From: Martyn White <Martyn.White@arun.gov.uk>
Sent: 15 November 2019 15:33
To: Planning.Responses <Planning.Responses@arun.gov.uk>
Cc: Anita Gardner <Anita.Gardner@arun.gov.uk>
Subject: AB/108/19/PL

AB/108/19/PL

GROUND FLOOR PLAN

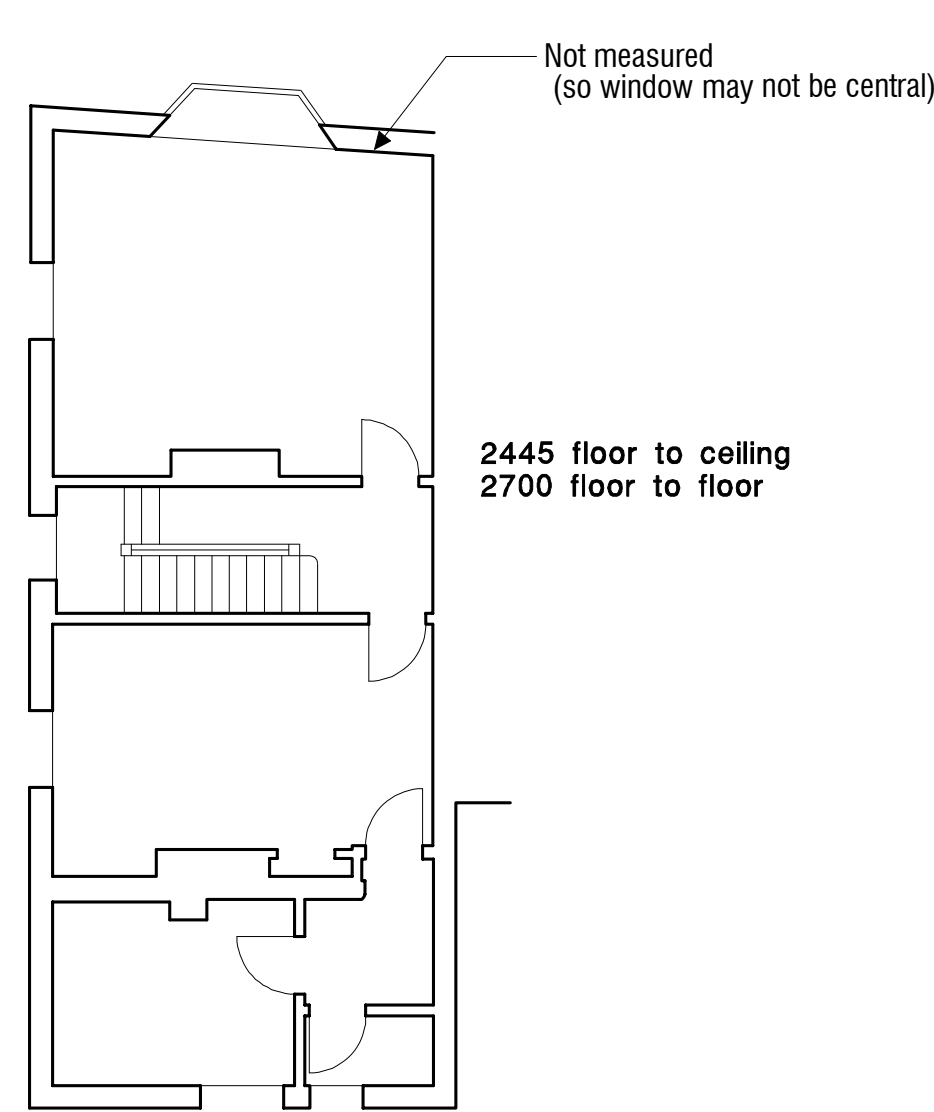
It is positive to note that the application proposes that the existing shop front will remain as it currently does. However, it is not clear if any building regulations requirements would mean that this should be altered to provide for ventilation. Any changes to this window could harm the elevation of the building and might not be capable of support.

The alterations to the rear of the unit will not be visible from the public domain and are therefore acceptable.
